**Re: APS Desert Willow Ph 2
Erosion and Sediment Control Plan
Engineer's Stamp Date 2-20-17 (G17E019)**

Based upon the information provided in your submittal received 2-22-17 the above referenced plan is approved to apply for an ESC Permit for grading and Building Permit with the following conditions:

A1 EROSION AND SEDIEMTN CONTROL PLAN
SCALE: 1" = 20'-0"

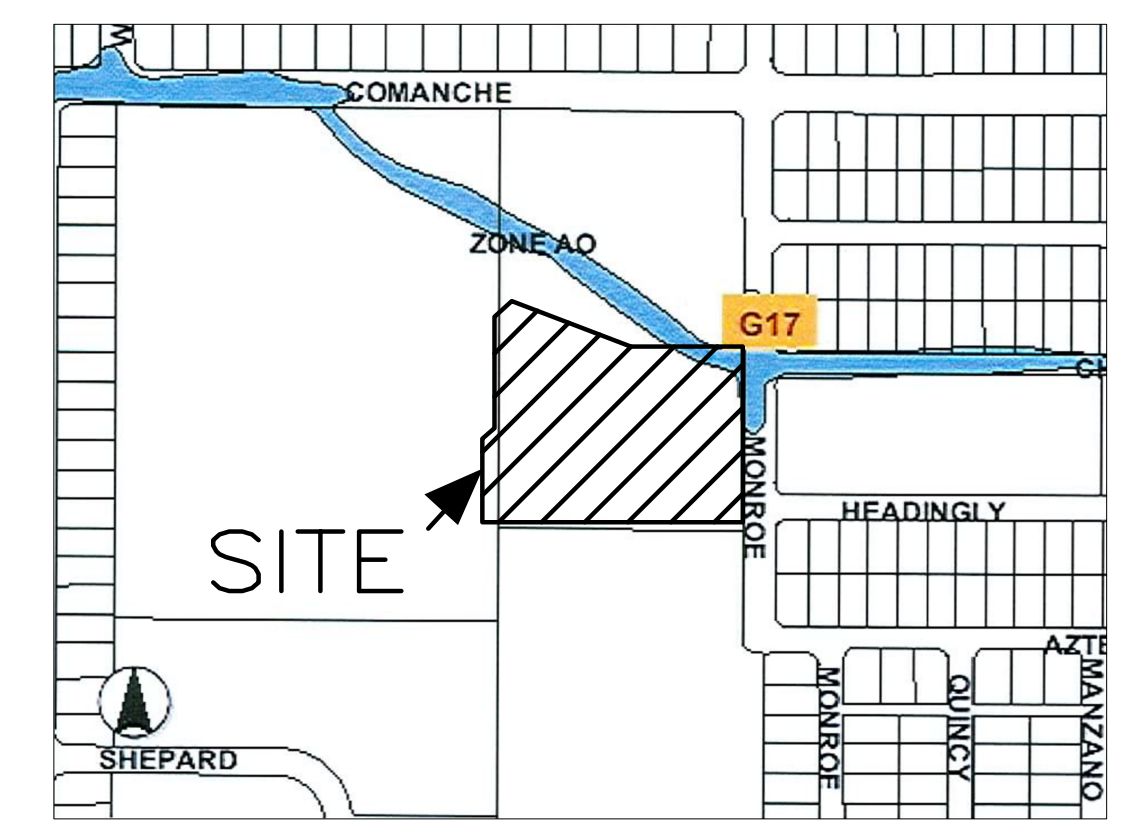
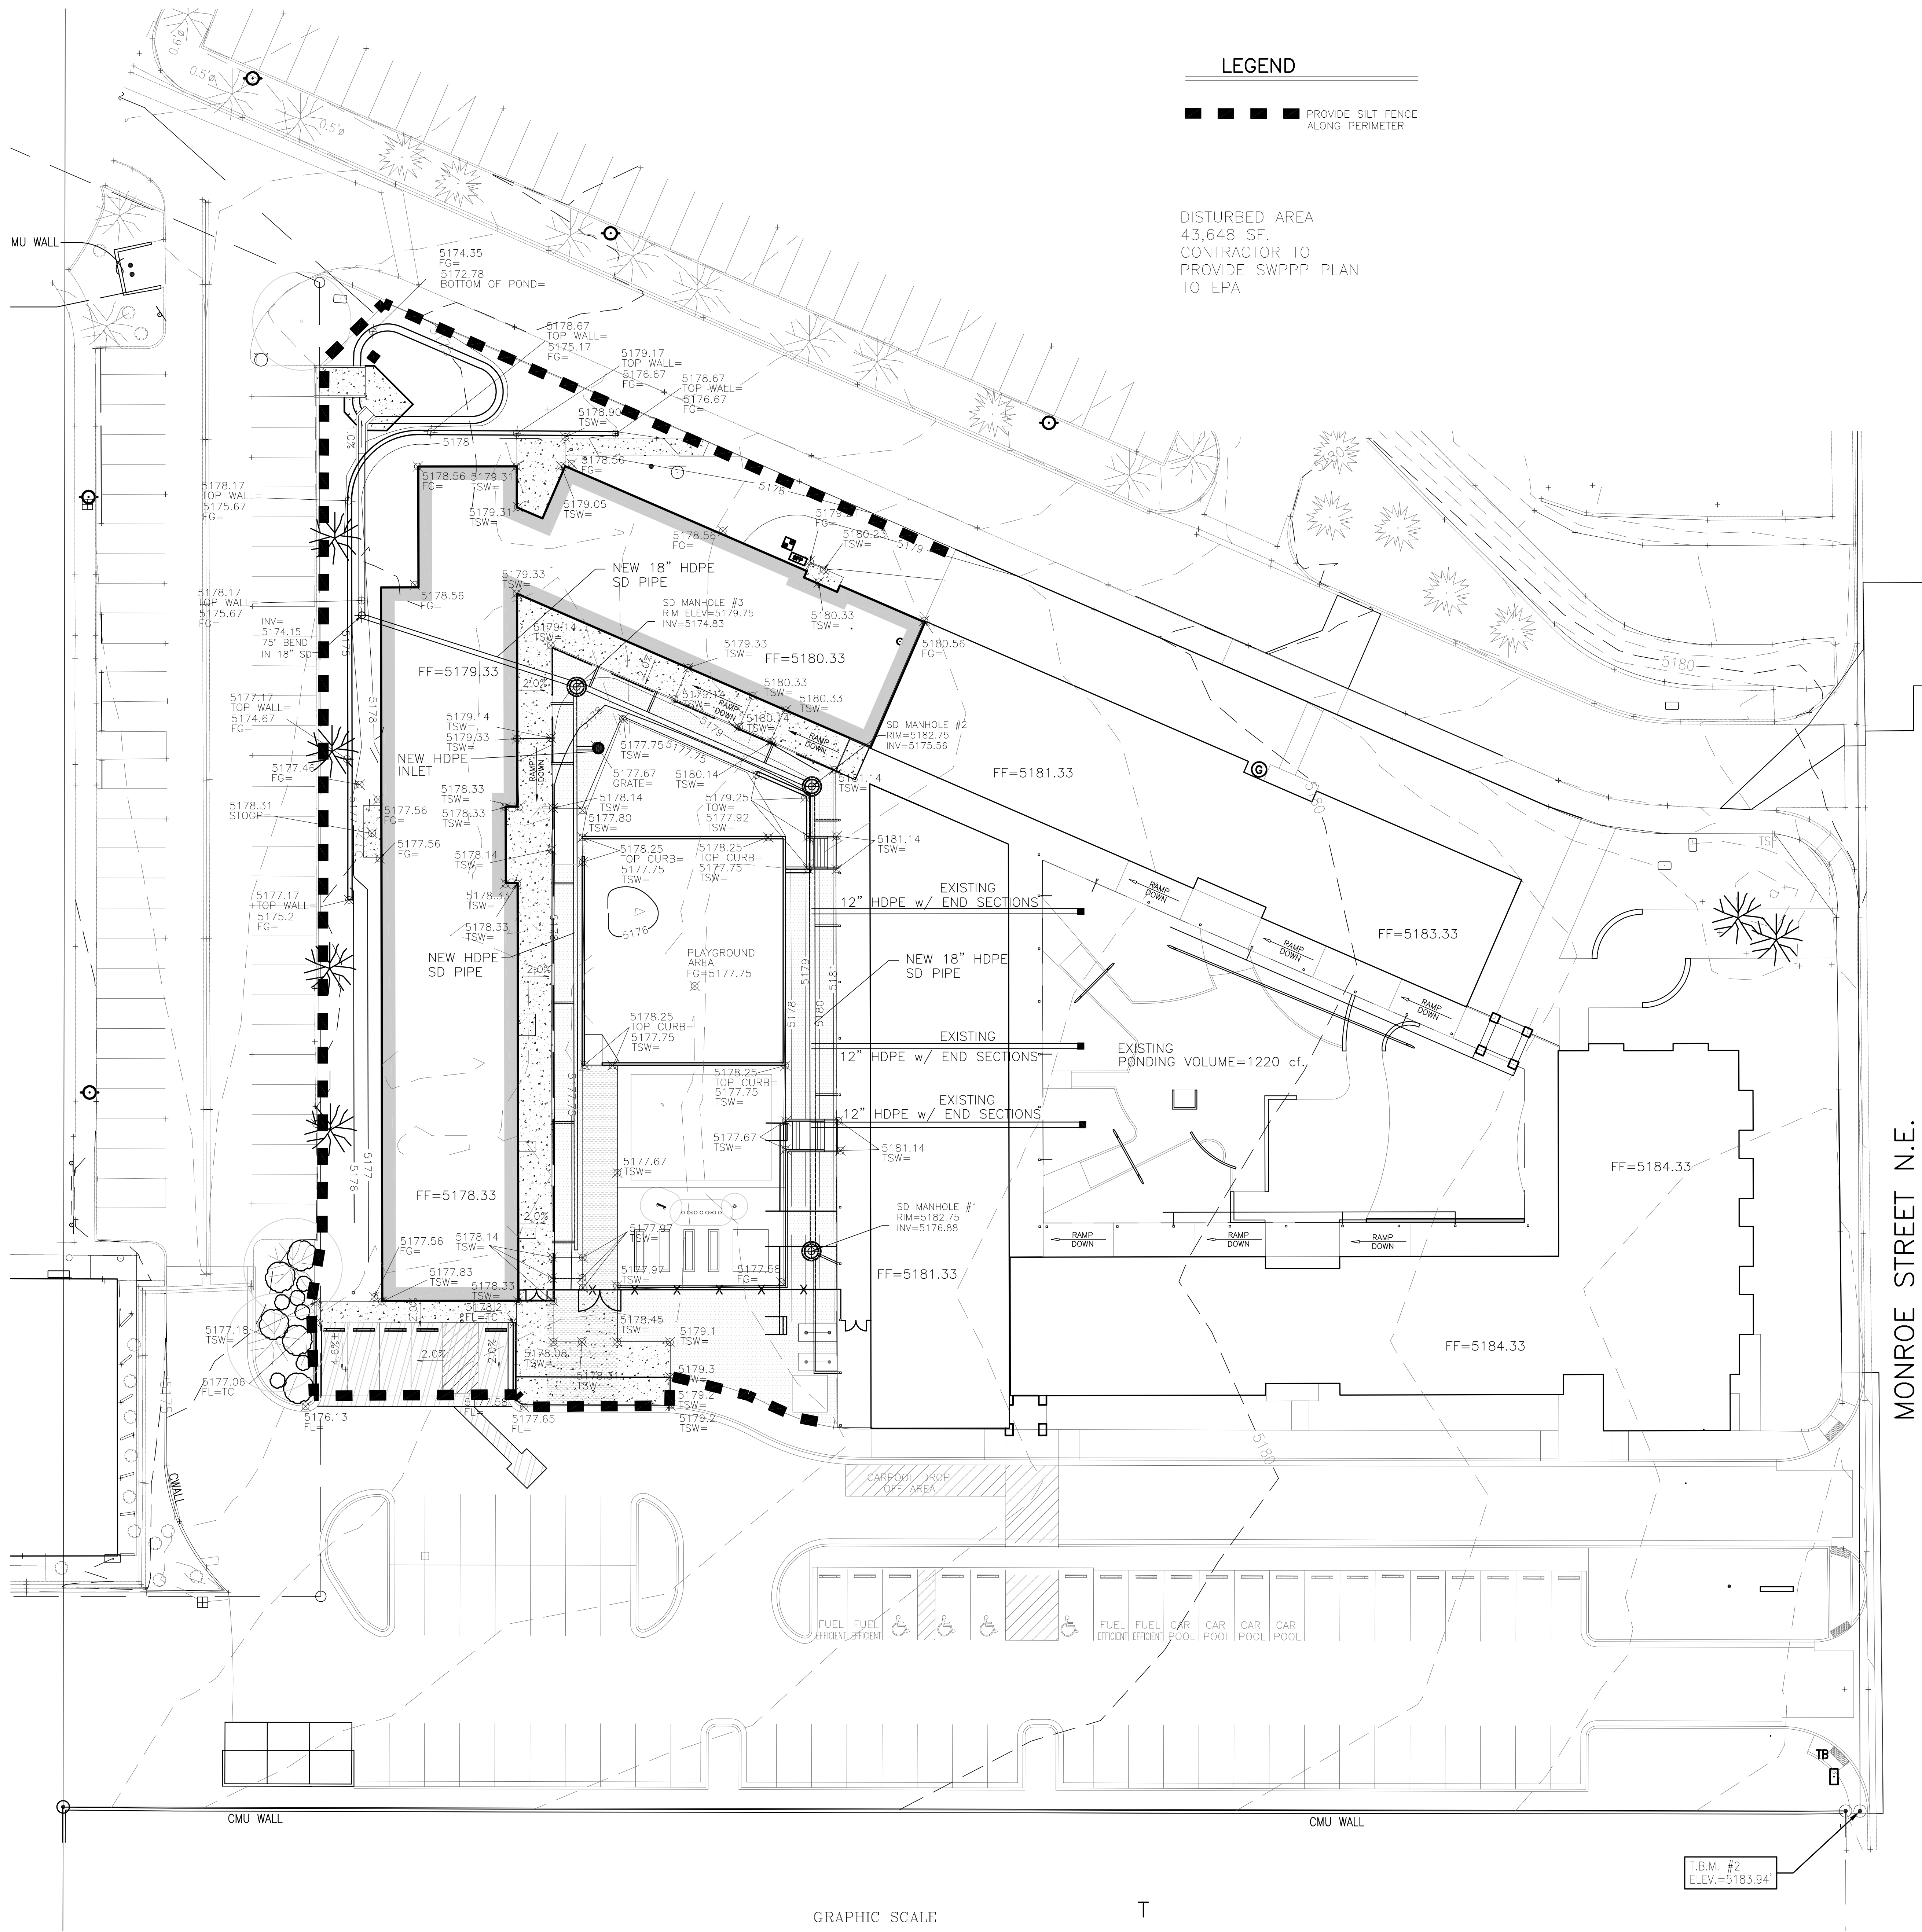
1. The plan should state that the asphalt road will be used for track-out control.
2. The plan shows silt fence across concrete near the pond, please inform your client that a wattle or filter sock is to be placed at the bottom of the silt fence in this location.
3. In the future, submit BMP installation details. Please inform your client that is to be installed per acceptable methods.
4. If there are inlets on the site to the West, inlet protection may be required.
